CITY OF ALBUQUERQUE

July 15, 2016

Re: APS Family School East Side
3303 Monroe NE
Traffic Circulation Layout
Engineer's/Architect's Stamp **6-10-16** (G17-D019A)

A1 TRAFFIC CIRCULATION LAYOUT
SCALE: 1" = 20'-0"

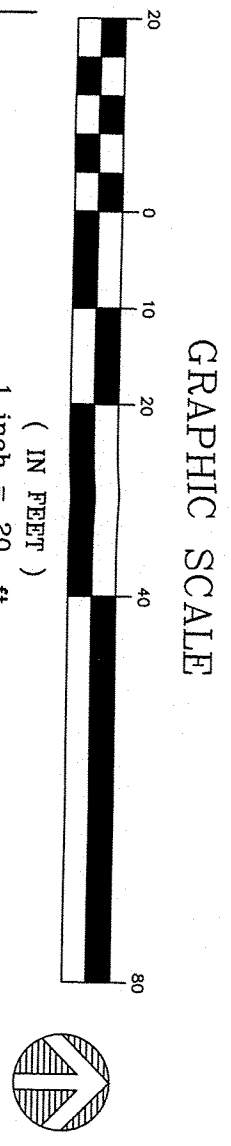
1. List the number of parking spaces required by the zoning code as well as the proposed number of parking spaces.
2. Please identify and detail all proposed buildings, doors, structures, sidewalks, curbs, drive pads, wall and anything that influences the parking and circulation on the site.

3. Identify and dimension all existing access easements and rights of way width dimensions.
4. Identify the right of way width, medians, sidewalks, ADA ramps, curb cuts and street widths on Monroe St. and Bus drop-off driveway.

5. Please list the width and length for all existing and proposed parking spaces, including HC spaces and access isles.
6. Label the compact parking spaces by placing the words "**COMPACT**" on the pavement of each space.

7. The handicap accessible spaces must be a minimum of 8.5 ft. in width.
8. The handicap accessible spaces must include an 8 ft. wide van access aisle; all other aisles should be 5 ft. in width.

9. The ADA accessible parking sign must have the required language per 66-7-352.4C NMSA 1978 "**Violators Are Subject to a Fine and/or Towing.**" Please call out detail and location of HC signs.

10. The ADA access aisles shall have the words "**NO PARKING**" in capital letters, each of which shall be at least one foot high and at least two inches wide, placed at the rear of the parking space so as to be close to where an adjacent vehicle's rear tire would be placed. (66-1-4.1.B NMSA 1978)

11. Show all drive aisle widths and radii.

12. Per DPM, a 6 ft. wide ADA accessible pedestrian pathway is required from the public sidewalk to the building entrances. Please clearly show this pathway and provide details.

13. Per DPM, a 6 ft. wide ADA accessible pedestrian pathway is required from the HC parking stall access aisles to the building entrances. Please clearly show this pathway and provide details.

14. Provide a min 6" or max 8" high concrete barrier curb or other acceptable barrier between landscaping and parking areas and/or drive aisles. Please call out detail and location of barrier curb.

15. One-way vehicular paths require pavement directional signage and a posted "**Do Not Enter**" sign at the point of egress. Please show detail and location of posted signs.

16. Please provide a sight distance exhibit (see the *Development Process Manual, Chapter 23, Section 3, Part D.5*). Please provide this detail for entrances/exits on Monroe St. and the north parking lot exit west of the proposed new Family School Phase 2 building.

17. Please add the following note to the clear sight triangle: "Landscaping and signage will not interfere with clear sight requirements. Therefore, signs, walls, trees, and shrubbery between 3 and 8 feet tall (as measured from the gutter pan) will not be acceptable in this area."

18. Please add a note on the plan stating "All improvements located in the Right of Way must be included on the work order."
19. All broken or cracked sidewalk must be replaced with sidewalk and curb & gutter. A build note must be provided referring to the appropriate City Standard drawing.
